COMMENTS ON SUBMISSIONS FOR DEADLINE 3A

Figure 8.16.1
Cottam 1 North (Sheet 1)
Landscape and Ecology Mitigation and Enhancement Plan
[EN010133/EX1/C.6.4.8.16.1.A]

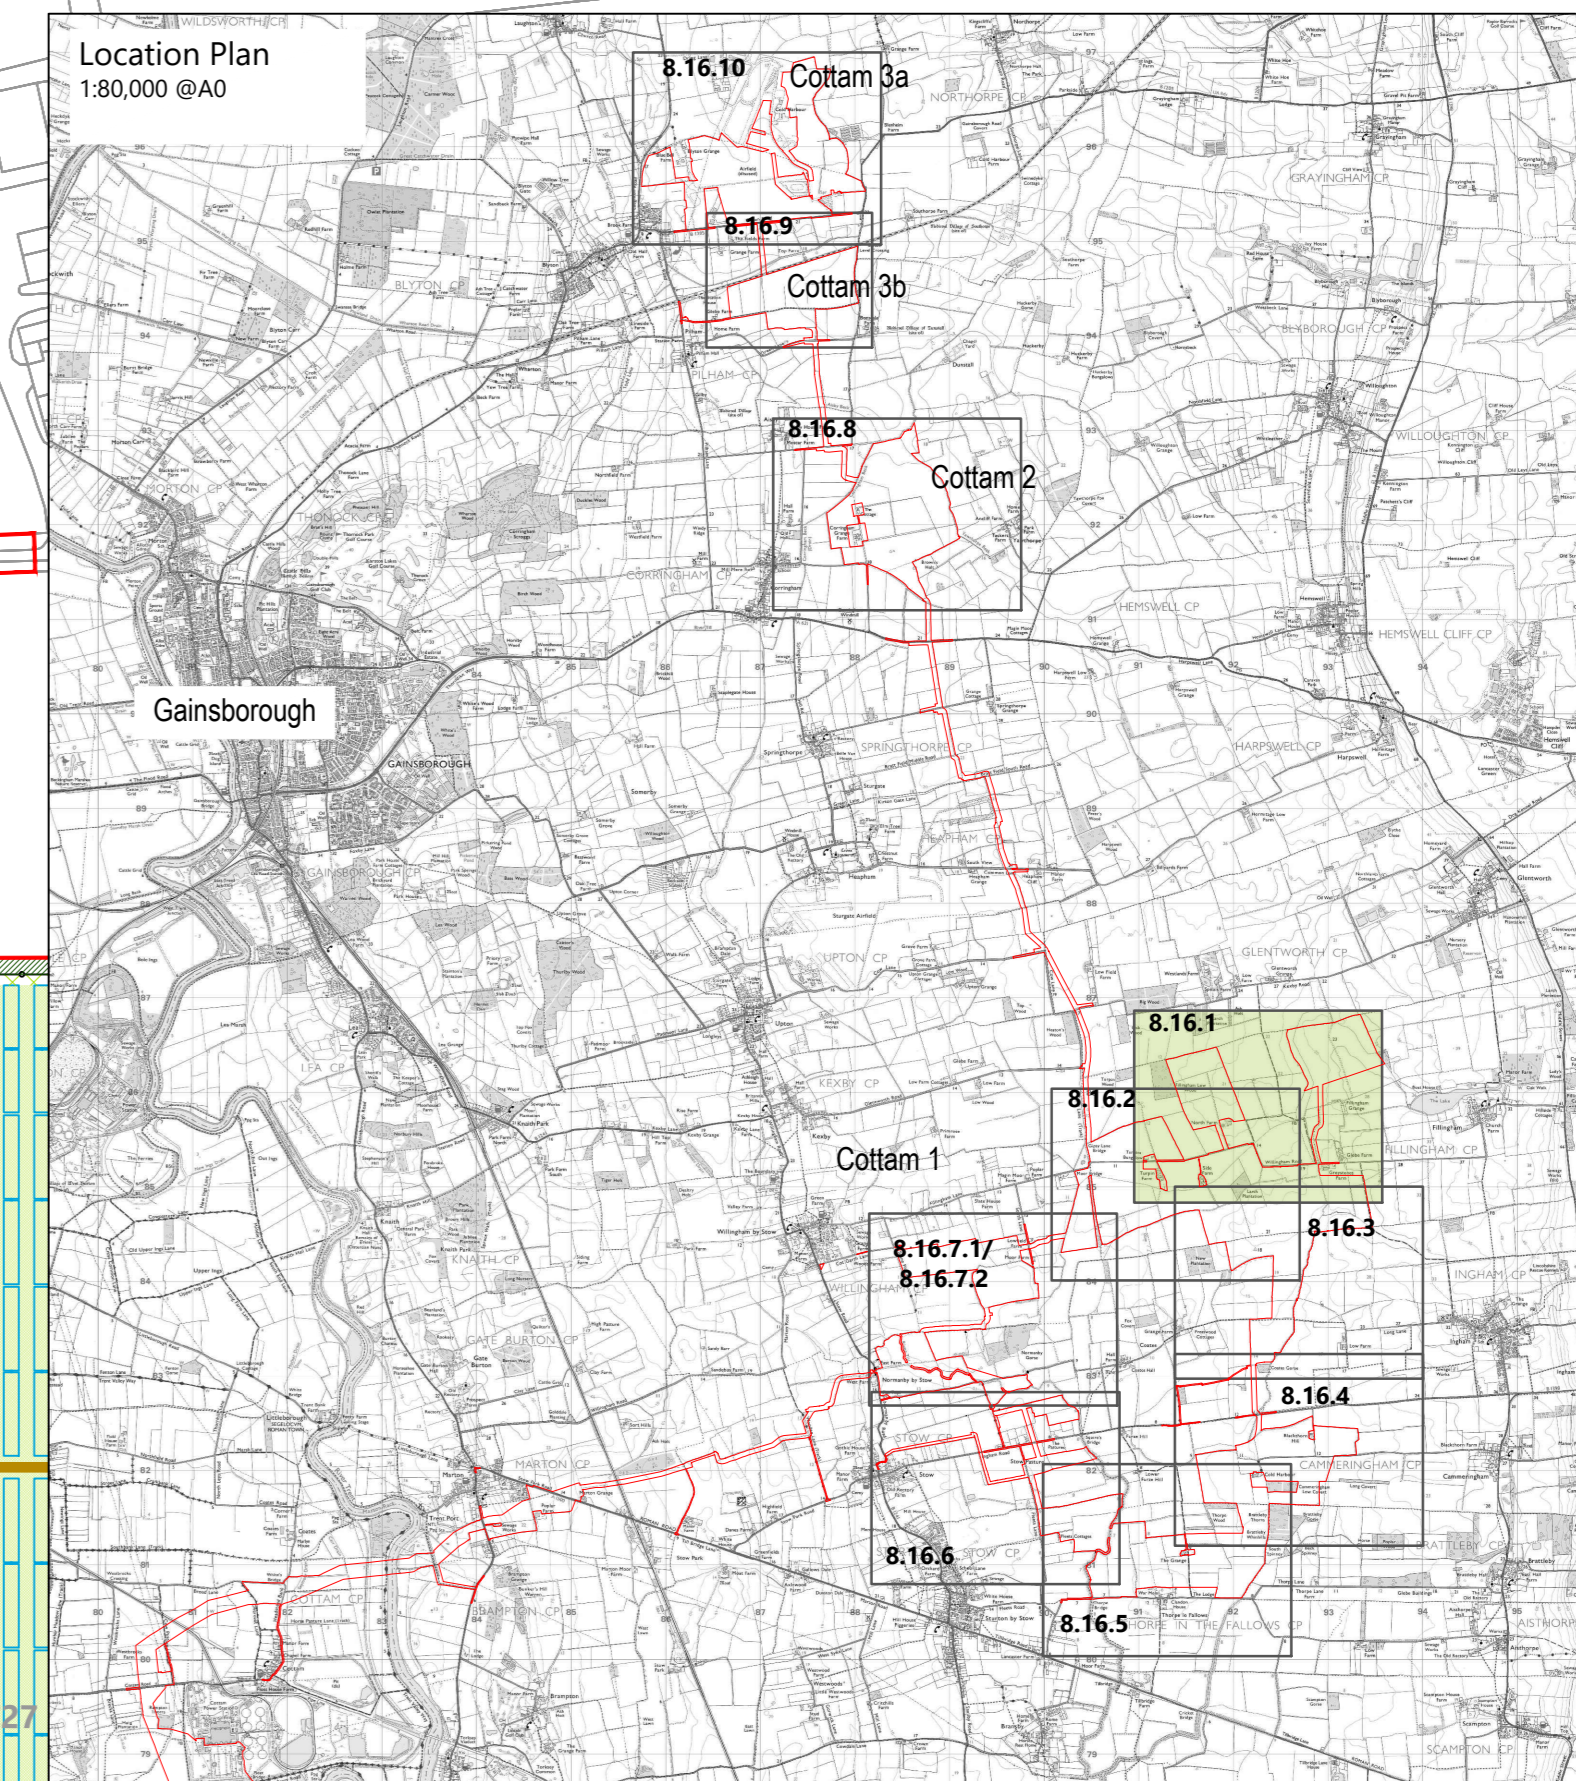
For example, the Cottam 1 site (along with the West Burton 1 and 2 sites) the farmland is experiencing excessive waterlogging preventing access by agricultural vehicles onto the land and the drainage ditches are beyond full. The Applicant has failed to fully address how they propose to prevent greater flooding occurring in these areas when there is excessively saturated farmland which is then followed with heavy and continuous rain or snowmelt. Waterlogged fields are currently causing crops to fail and in the images below on a field opposite West Burton 2 the young crop planted last year has been destroyed.
